Subject: REF BE/100/19/PL Eppinghoras

I have just returned to office following compassionate leave. I write to confirm that we are organising an ecological survey and providing updated tracking/visibility plans to satisfy the highways consultation (whereupon we will also clarify the land ownership query).

REAR ELEVATION
(NORTH-EAST)

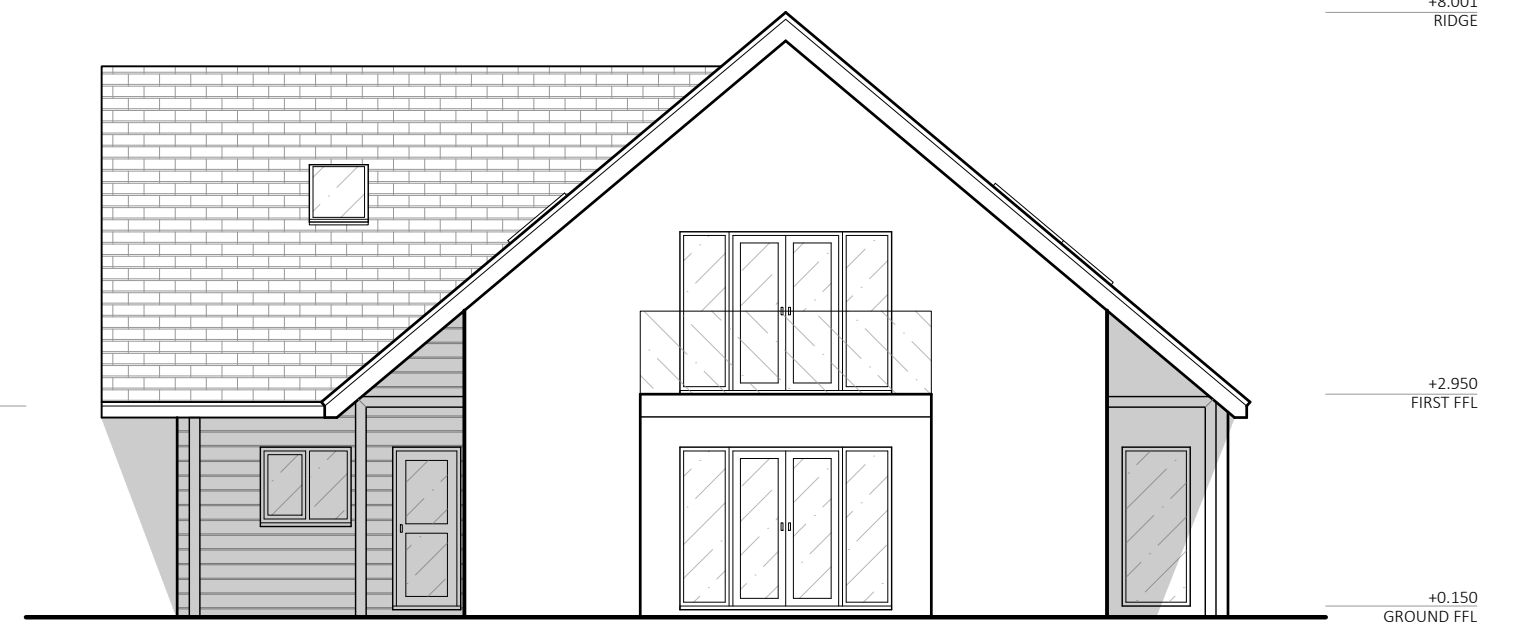
I also have some concerns with the proposed house designs in that the two pairs of Juliet balcony windows will allow overlooking of each other and also that the balcony on the south elevation to plot 1 will overlook the approved new dwelling. I note that there are limited windows on the rear east elevation (at FF) and wonder if more could be made of this elevation to avoid the overlooking from the flank FF windows.

I attach the ecological survey for the application. The recommendations with regards hedgerows have been adopted into a revised site layout plan, attached. We have also had consideration to your design comments, and issue updated floor plans and elevations.
